Indaver Rivenhall IWMF DCO

ENVIRONMENTAL STATEMENT [PINS Ref: EN0101038]

ES APPENDIX 5.4: SCHEDULE OF STATUTORY CONSULTEE COMMENTS AND RESPONSES

Document Reference: EN0101038/APP/6.2

Figure 8.1: Sensitive Receptor Locations identified in Condition 38

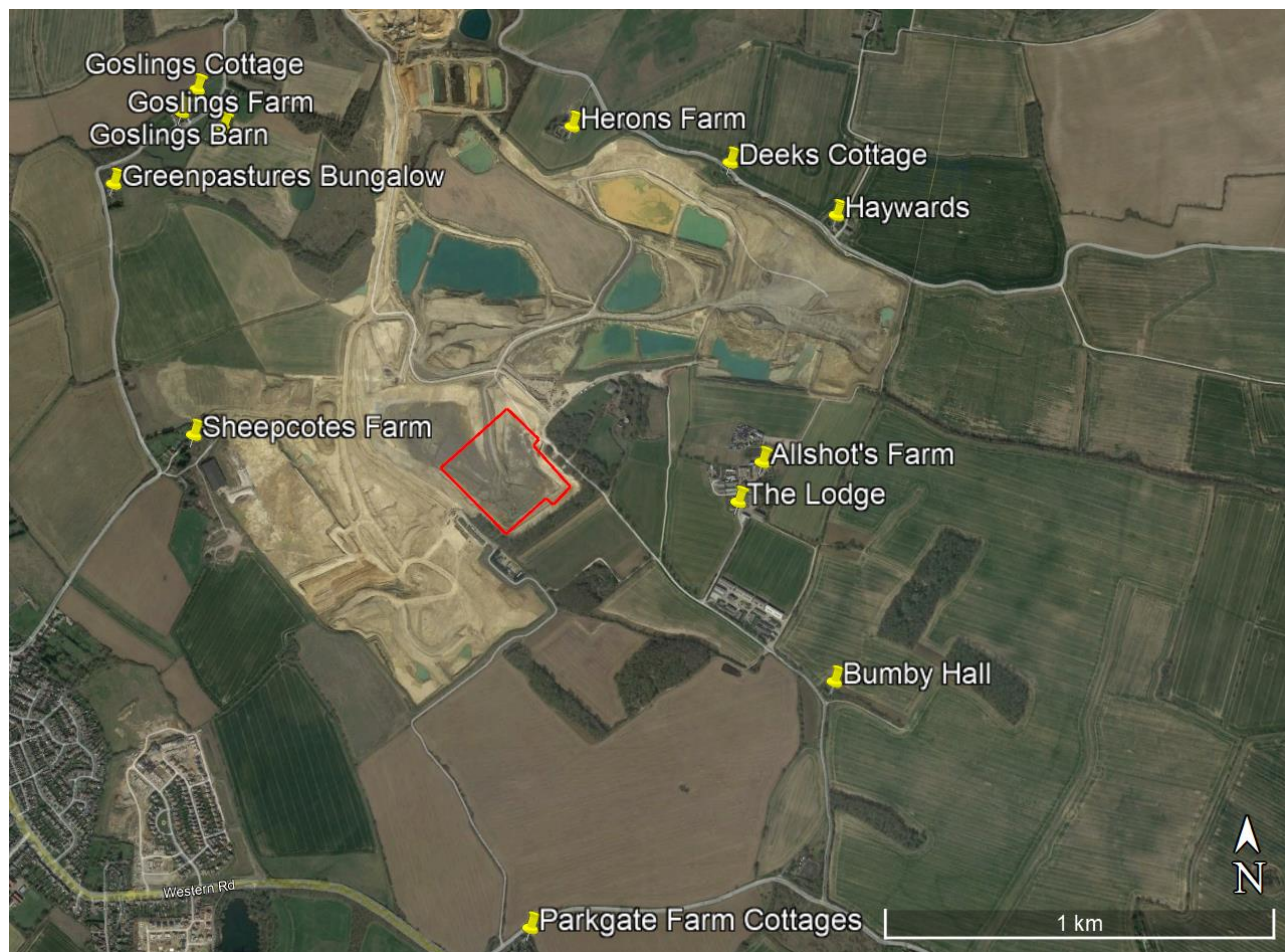
Topic	Consultee(s)	Summary of Comment	Action / Response
General	Planning Inspectorate	Use Integrated Waste Management Facility then the abbreviation IWMF – comments were made in scoping that people didn’t understand what the acronym stood for	Noted. Glossary is provided in ES Volume 1 (Doc Ref. 6.1)
		In paragraph 3.4.1 (re. Works No 1), can you be more specific than ‘a few days’?	A more specific timeframe has been provided in ES Chapter 5: Description of the Proposed Development (Doc Ref. 6.1)
Carbon emissions	Braintree District Council	Whilst the documentation states that there will be no increase in direct greenhouse gas emissions from the facility, this statement could be misleading (Para 7.1 to 7.4 PEIR Non-Technical Summary). It doesn’t cite the scope 1, scope 2 or scope 3 emissions of the plant despite the fact it will be overall positive from a carbon emissions point of view.	<p>There will be no change to the combustion process and so there will be no change to the direct greenhouse gas emissions from the facility. This statement is not considered misleading.</p> <p>References to scope 1, 2 and 3 emissions have been added to ES Chapter 7: Climate Change and Greenhouse Gases (Doc Ref. 6.1)</p>
